**ADC Planning Consultation  
Response from the Historic Buildings Adviser**

| <b>Application Number</b> | AB/72/14/HH & AB/73/14/L                                    |
| <b>Address</b>            | 43 King Street, Arundel, BN18 9BJ                           |
| <b>Description</b>        | Single storey extension, alterations to existing structure. |

DRG. No.	13151-02 A
SCALE	1:50
DATE	November 2013
DRAWN	SR
CHECKED

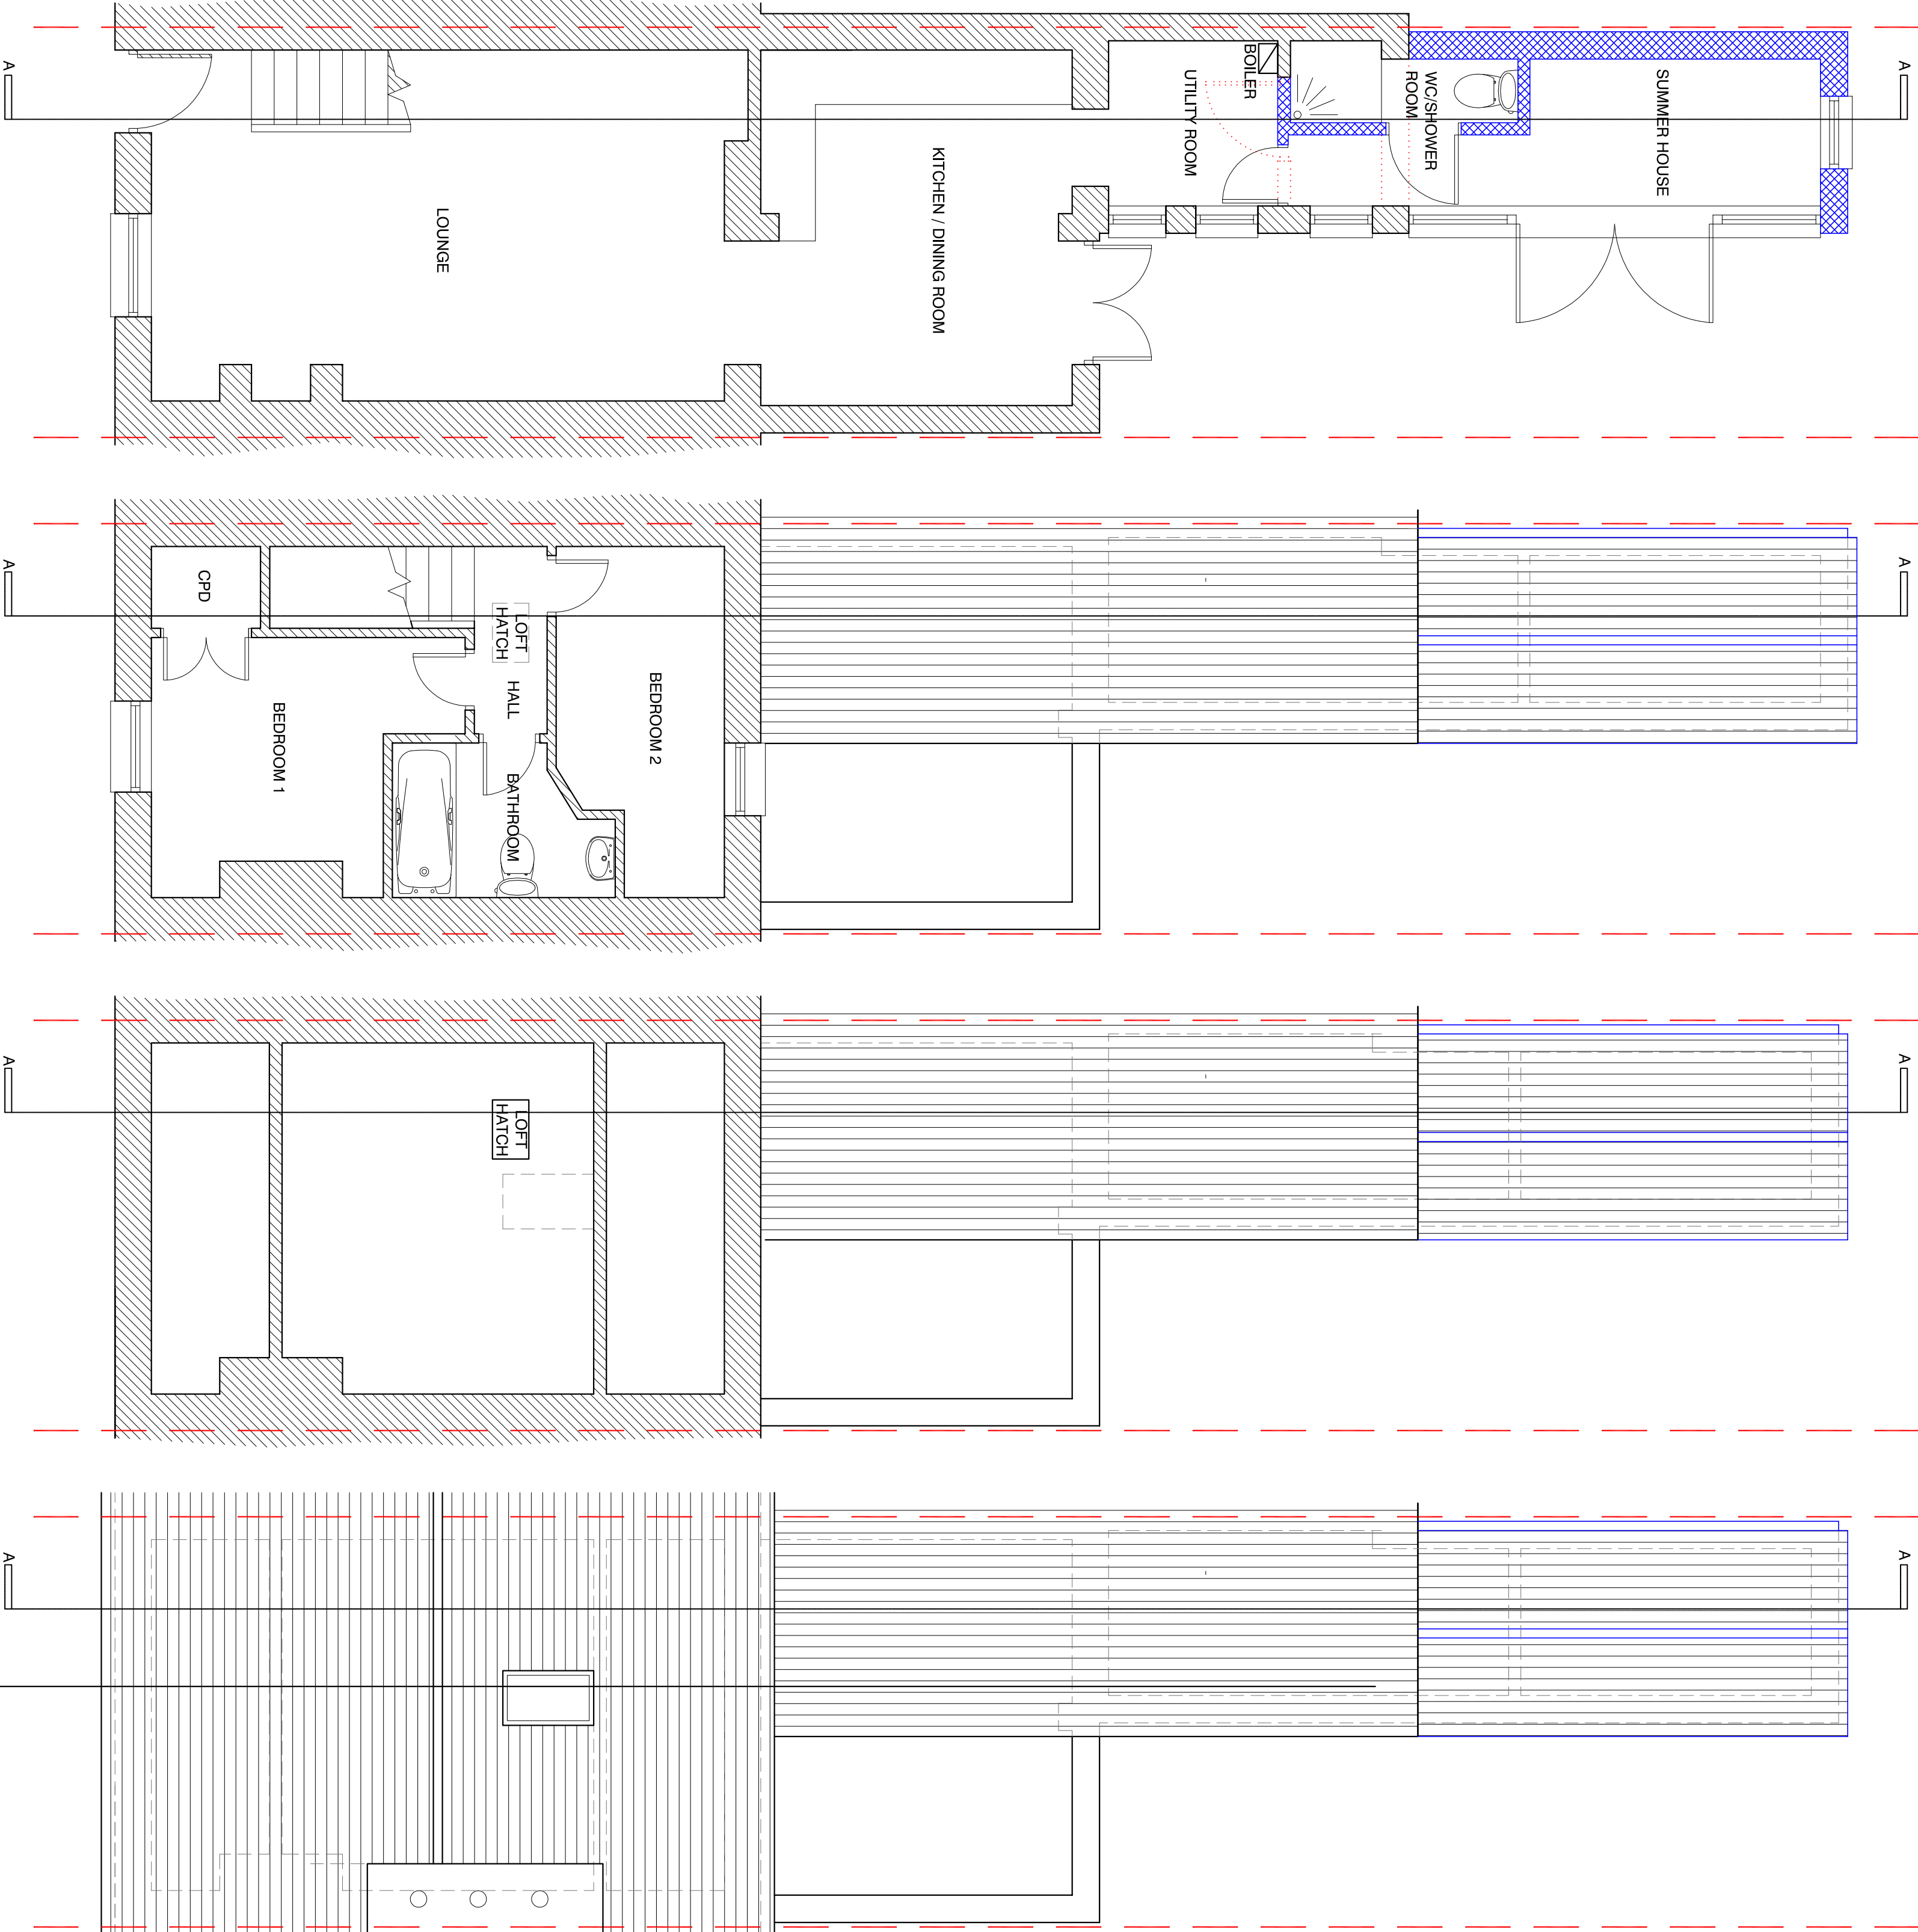
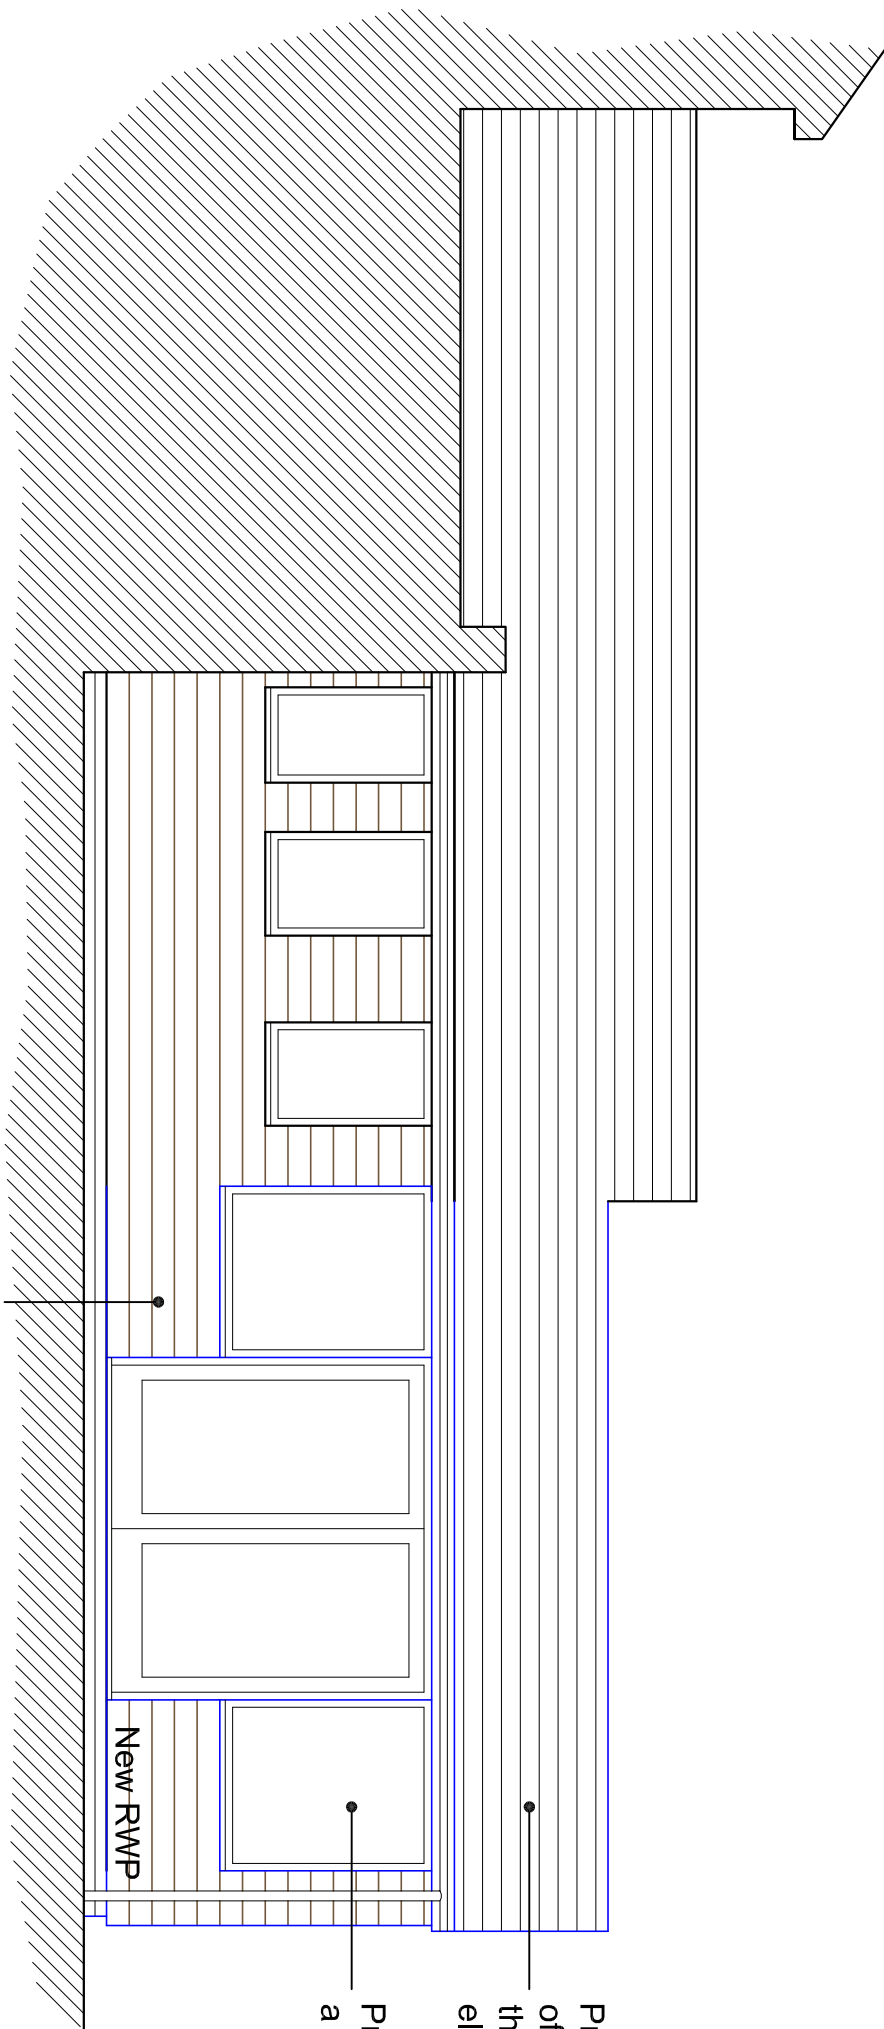
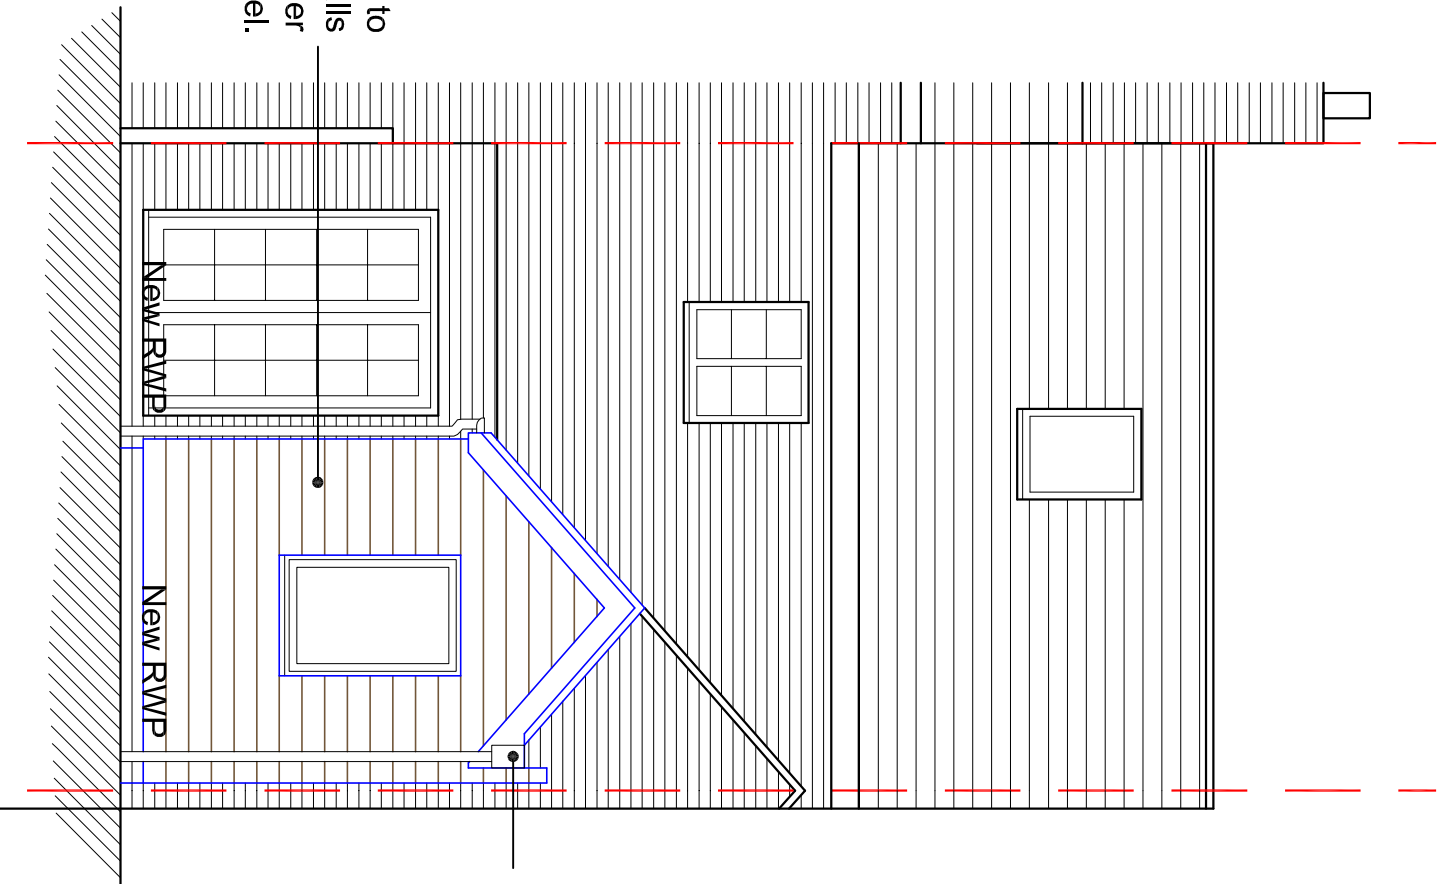
Firstly, given that the building to which the 'summer house' is being attached, appears to be of good quality, the level of loss to form an opening whilst maintaining a WC seems excessive. There is also an issue with the how the new structure will abut the old, particularly how the roof pitch cuts across the brick detailing. The change in roof slope is also rather incongruous.

There are also concerns with the design itself. The French doors with large windows either side is not particularly sympathetic, nor is it of a design quality or finish befitting a listed building in an urban setting
